From: David Senus <dsenus@woodardcurran.com>
To: Jean Fraser <JF@portlandmaine.gov>
CC: Michael Farmer <Mfarmer@portlandmaine.gov>, "Thomas.Errico@tylin.com" <Thomas.Errico@tylin.com>
Date: 11/7/2013 1:15 PM
Subject: RE: final comments re 133 York Street

In reading through the Construction Plan for 133 York Street, I offer the following comments:

3 STABILIZED CONSTRUCTION ENTRANCE DETAIL NOT TO SCALE

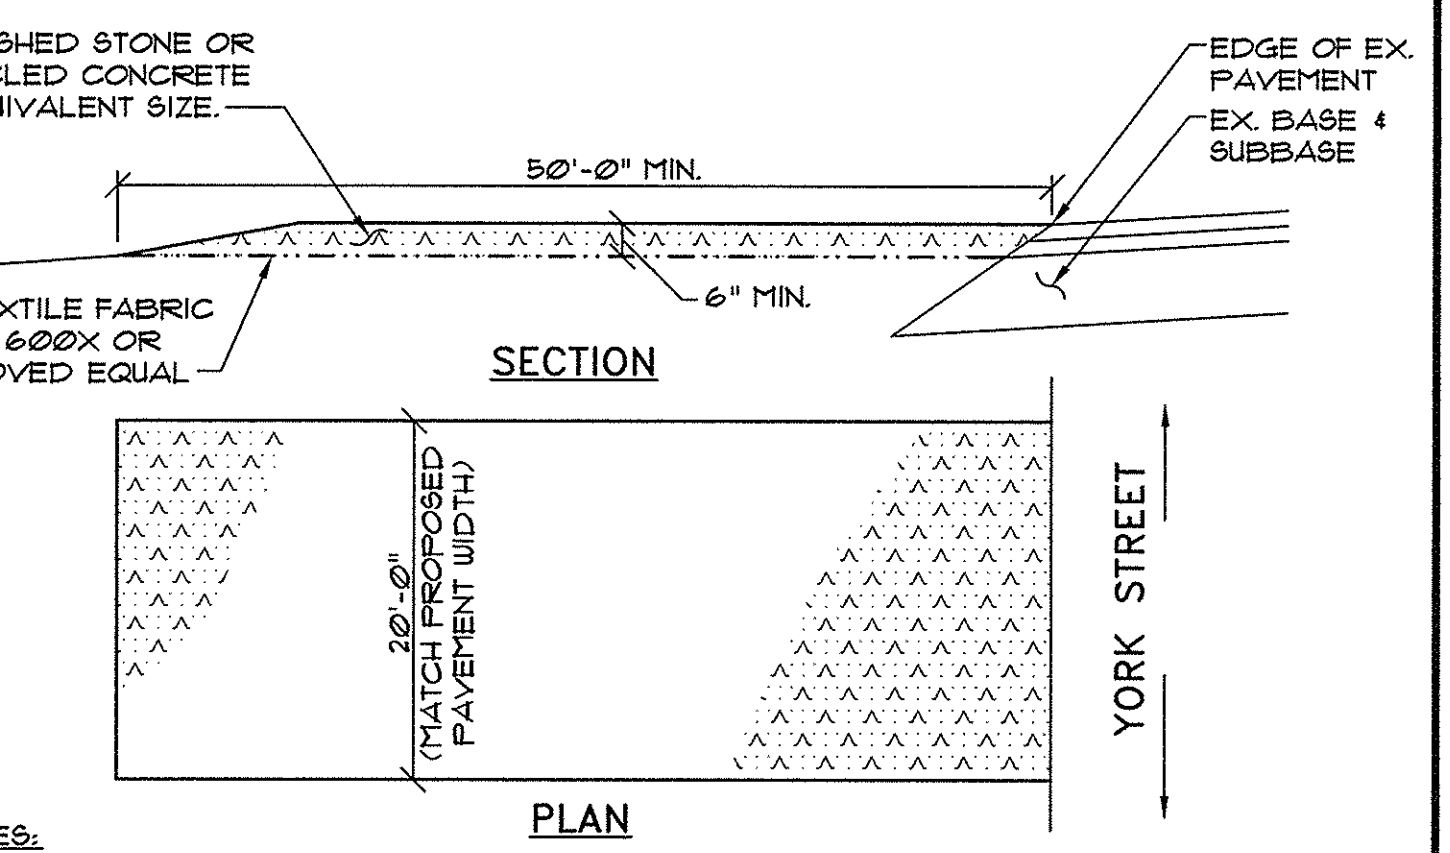
- >The plan should note that a stabilized construction entrance/exit will be constructed at the York Street driveway per the Erosion and Sediment Control Plan, and that the York Street Right-of-Way shall be kept clean from dust and construction debris and swept as determined necessary by the Contractor or as requested by the City of Portland to minimize dust and sediment originating from the site.
